CITY OF ALBUQUERQUE

**Re: Storm Cloud Unit 4 Lots 55-69
Request for Engineer Pad Certification – Not Accepted
Engineer's Stamp dated: 11-7-16 (H09D022A)
Certification dated: 6-12-17**

RETAINING WALL PLAN NW

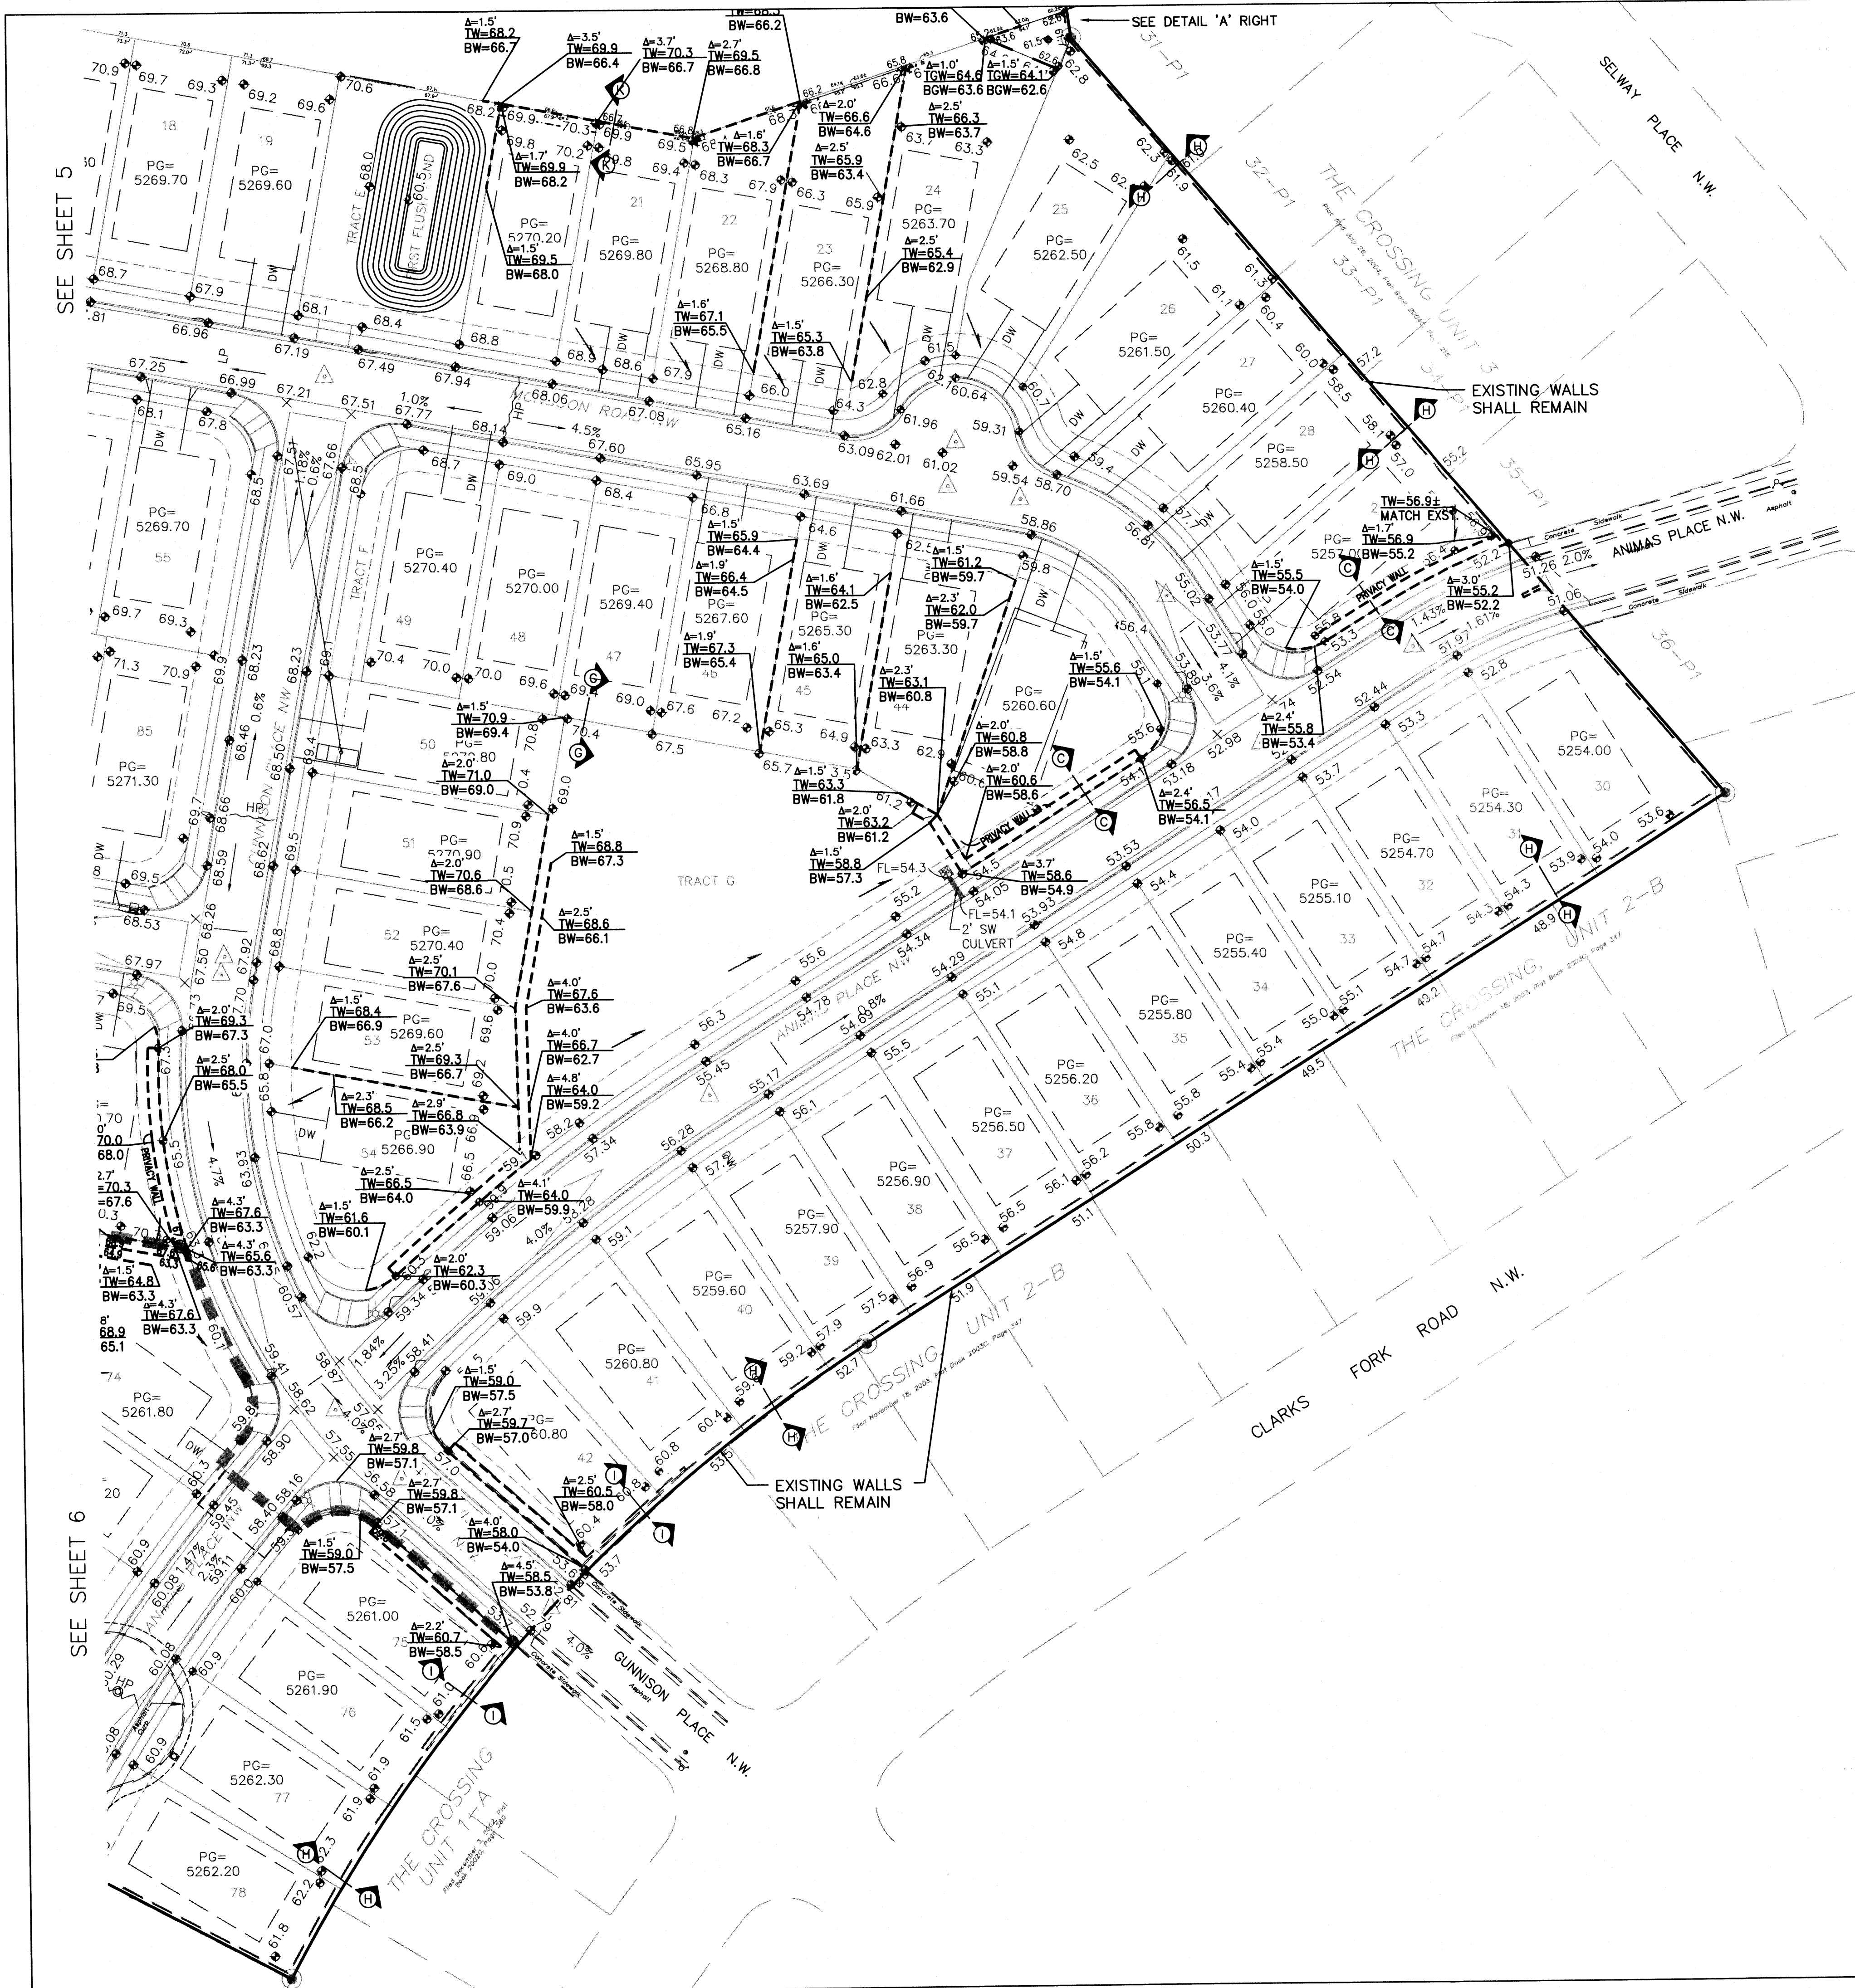
- The retaining wall between lots 64 and 65 is missing.
